Consultation Response from KC, Highways Development Management (HDM)

2024/91023 - Land Off, Woodhead Road, Brockholes, Honley, Holmfirth

Erection of 4 dwellings with landscaping and associated infrastructure

Date Responded: 04/07/24 | Responding Officer: A Darwin | Responding Ref: HDC 3-49/7

Drawing Title
**DG1/TG1 Garage
Double/Twin Detached Garage
6m x 3m Internal Garages
Plans, Section & Elevations**

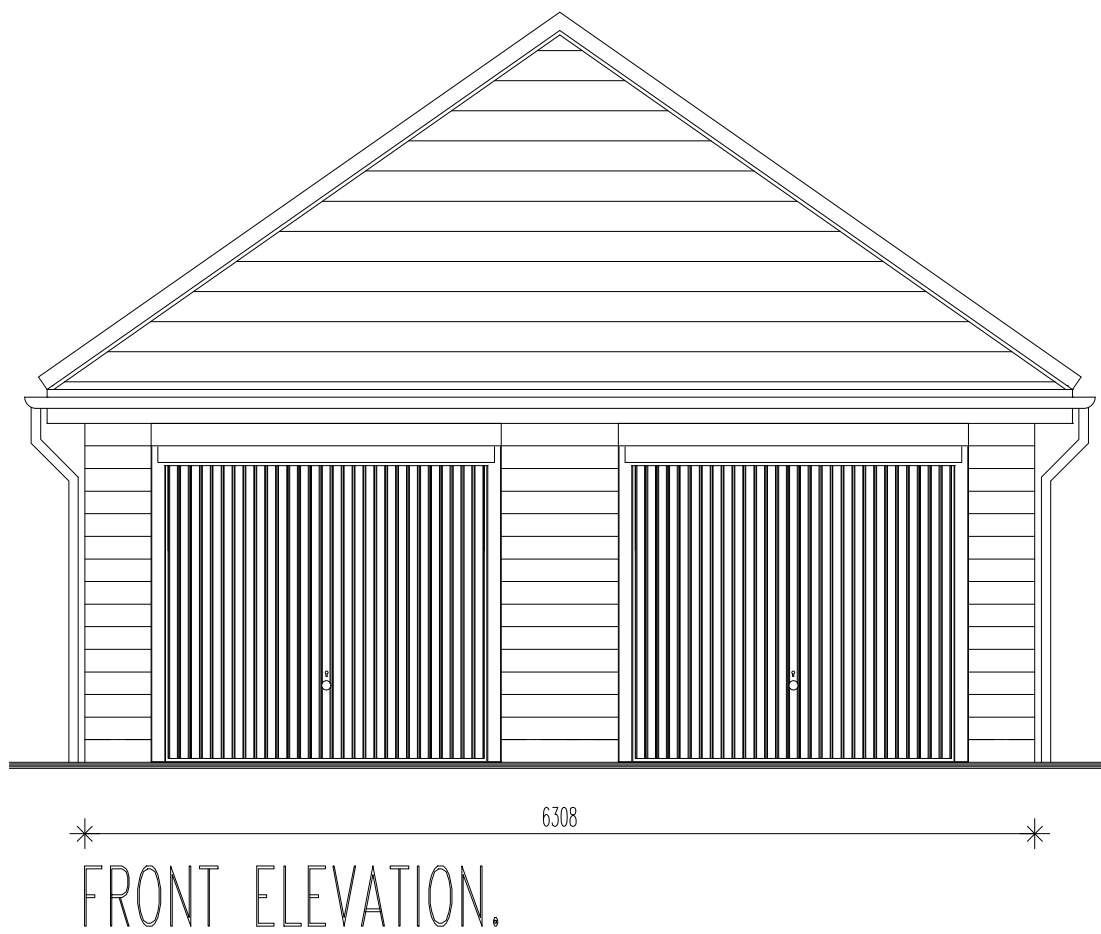
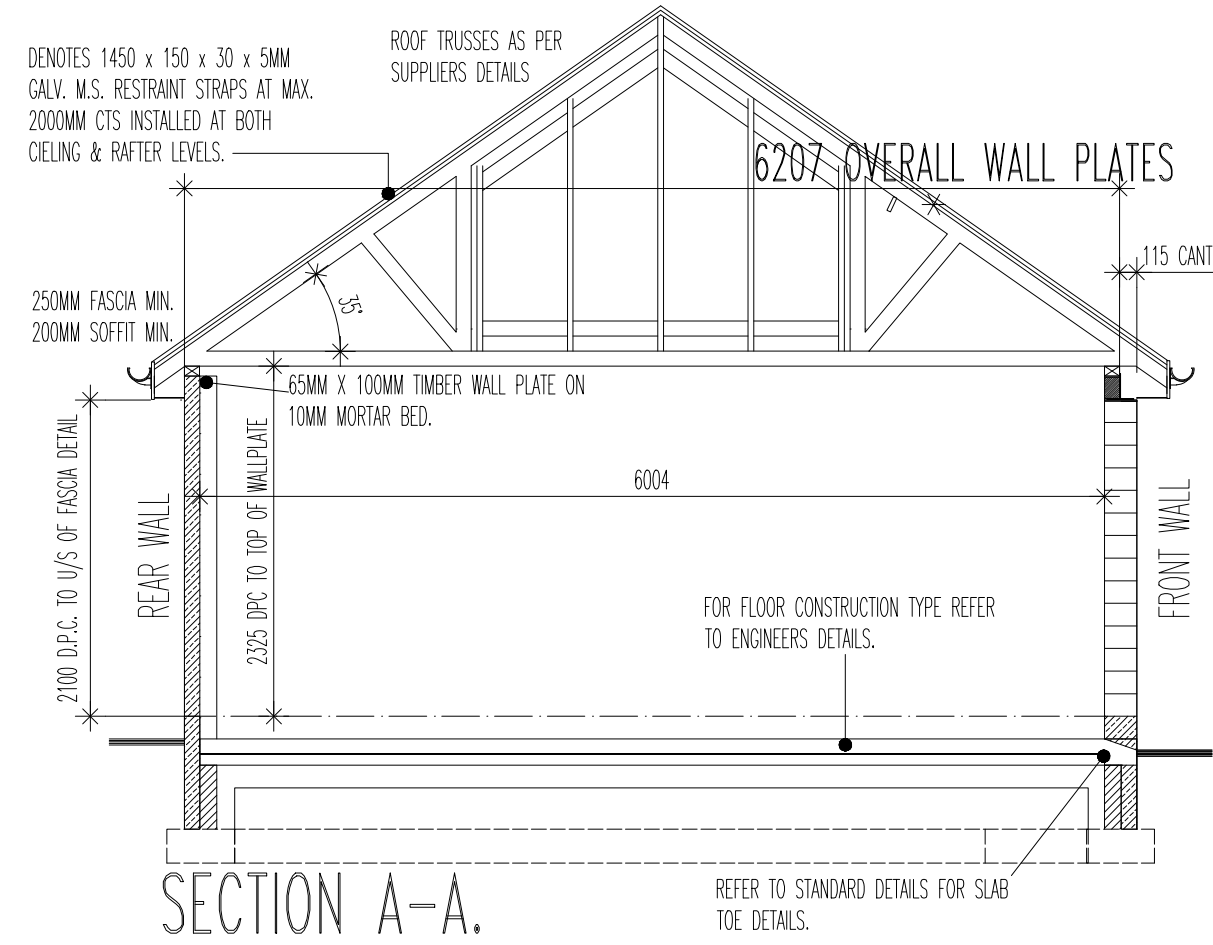
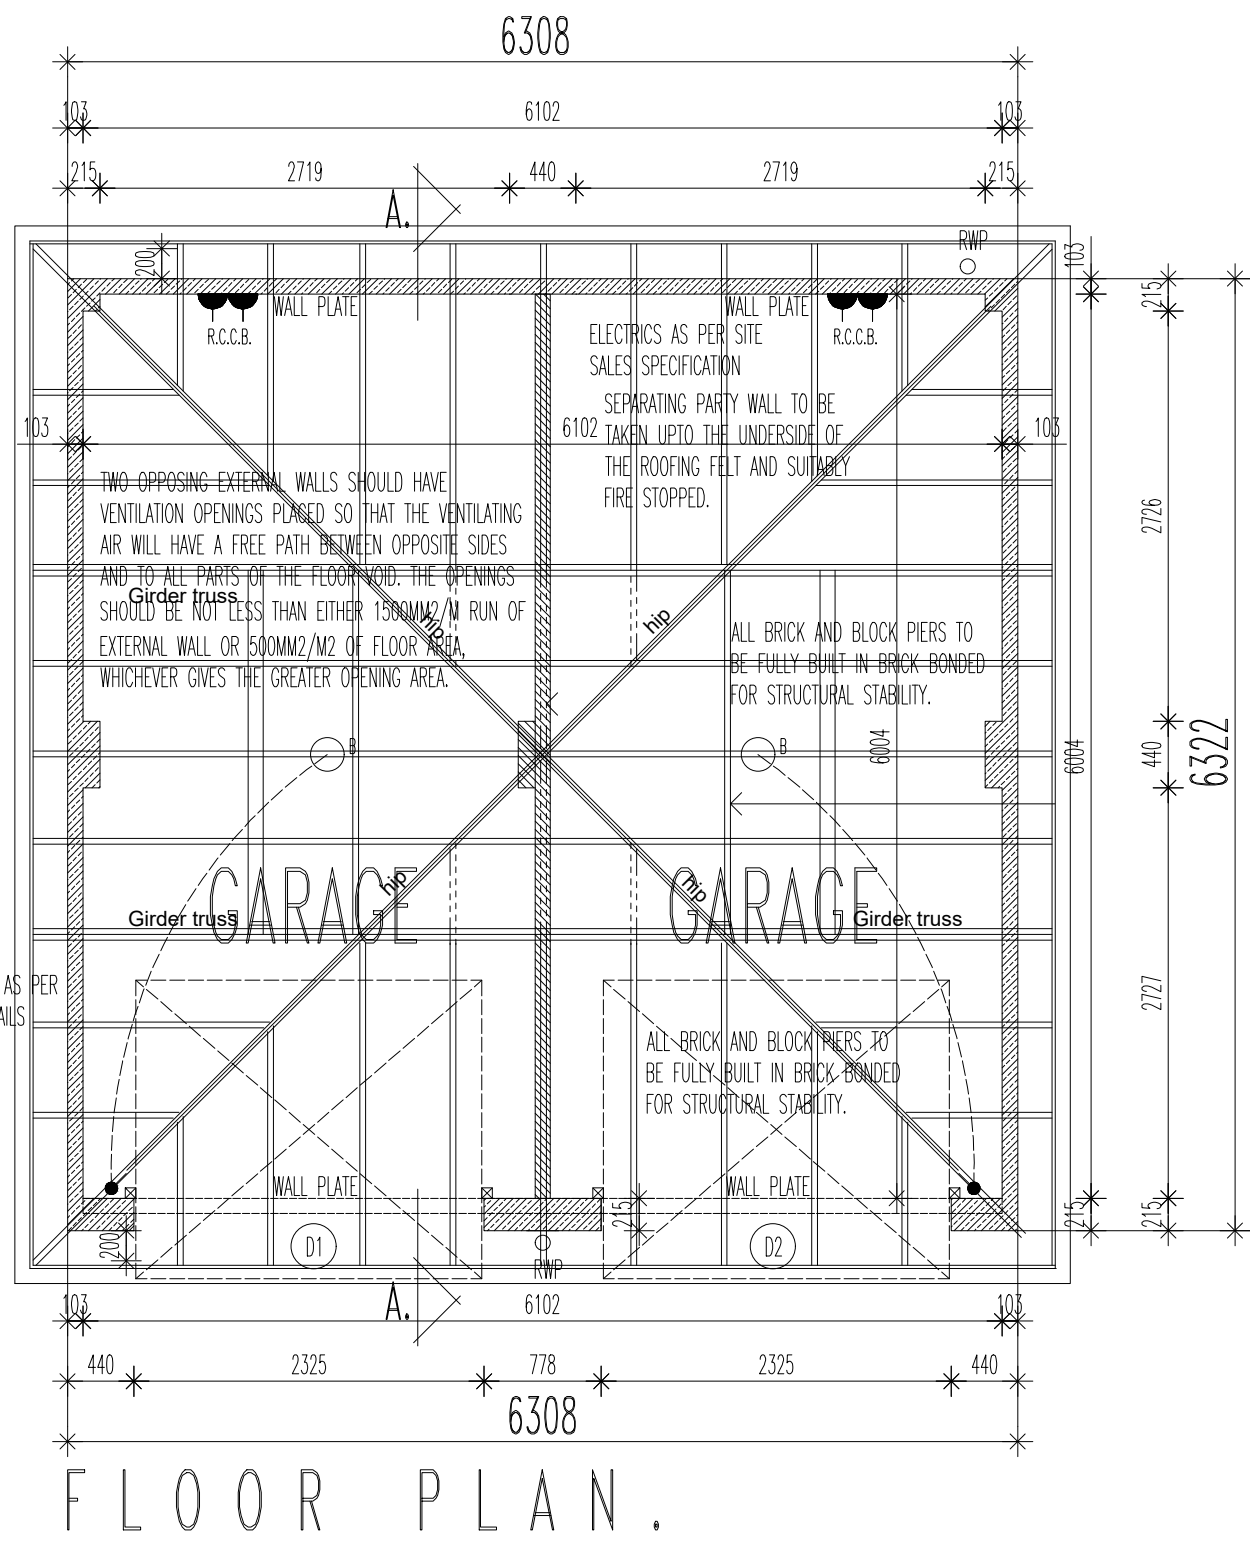
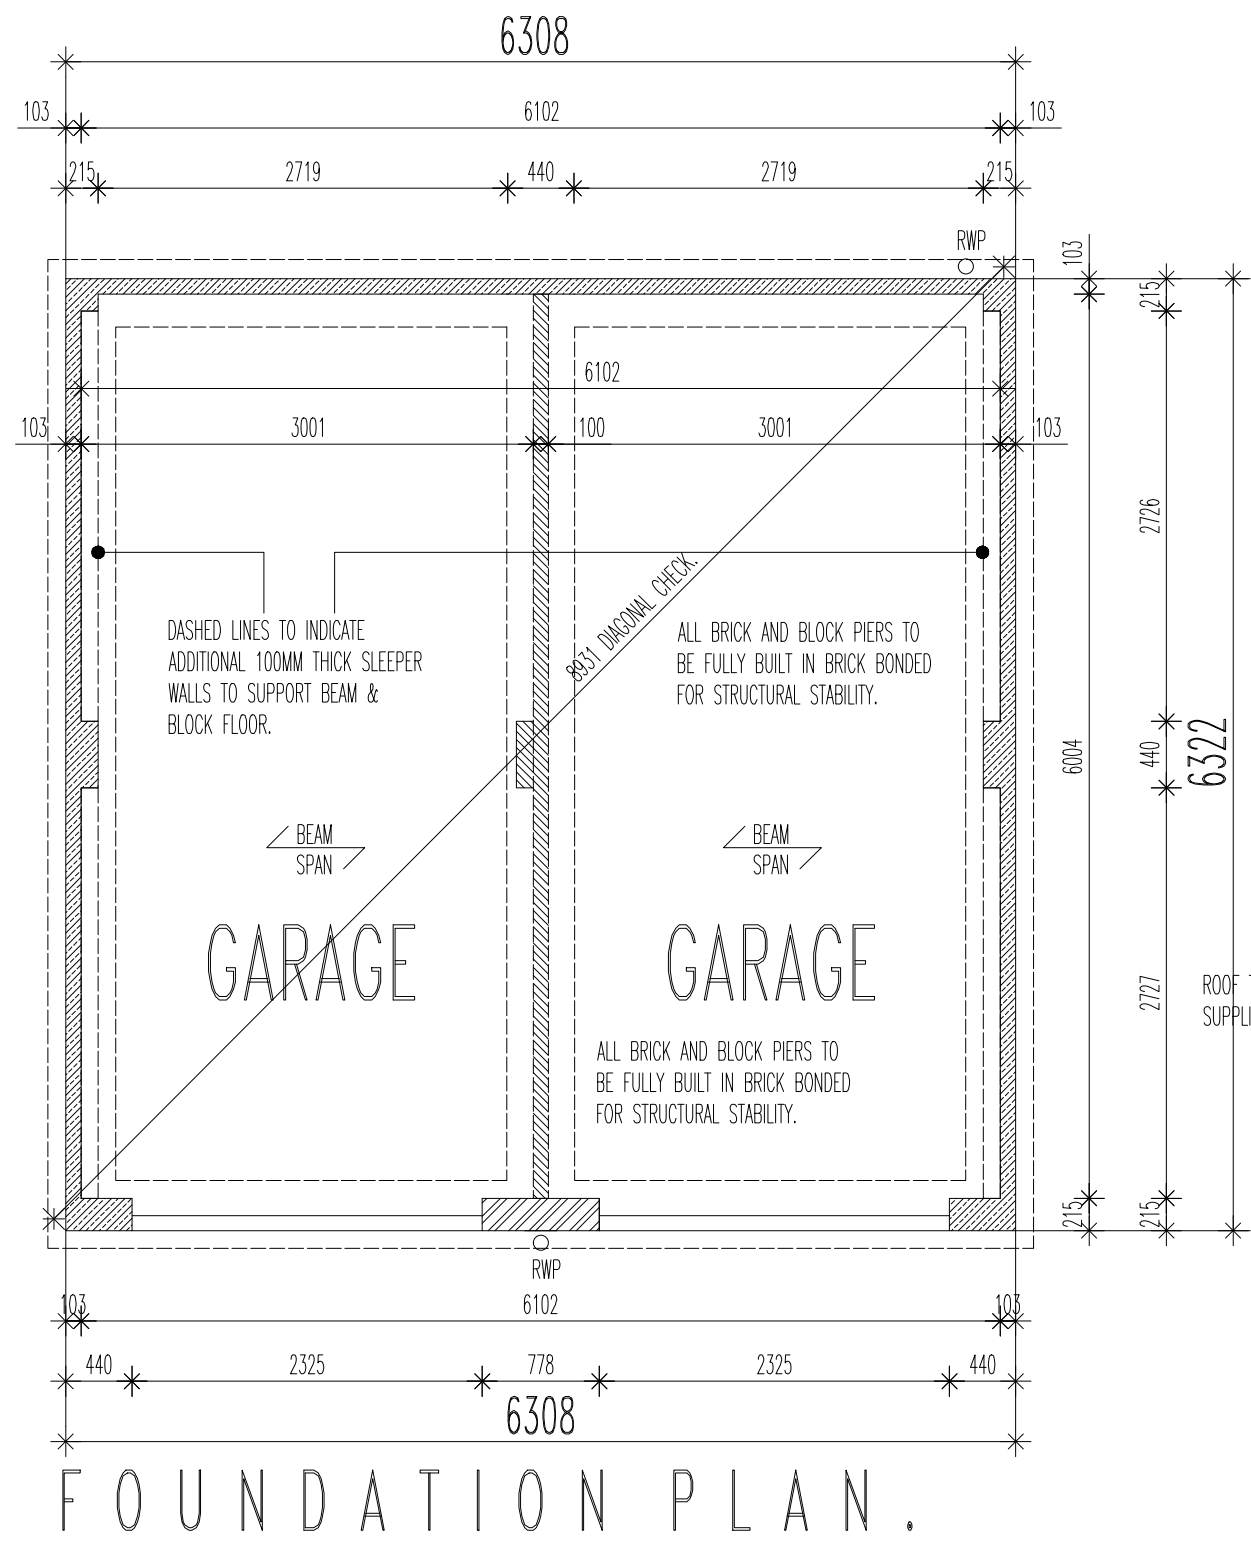
The proposal includes 2 no. 4 bedroom & 2 no. 5 bedroom dwellings. Each dwelling includes 2 no. surface parking spaces, with single and double garages provided for the 4 and 5 bedroom dwellings respectively. The supporting plans confirm that the internal dimensions of the garages are at least 3x6m, which is in accordance with minimum local standards. Therefore, the level of car parking provision is in full accordance with the Kirklees Council Highway Design Guide SPD, and includes garages that will facilitate secure cycle parking for all dwellings, and is acceptable.
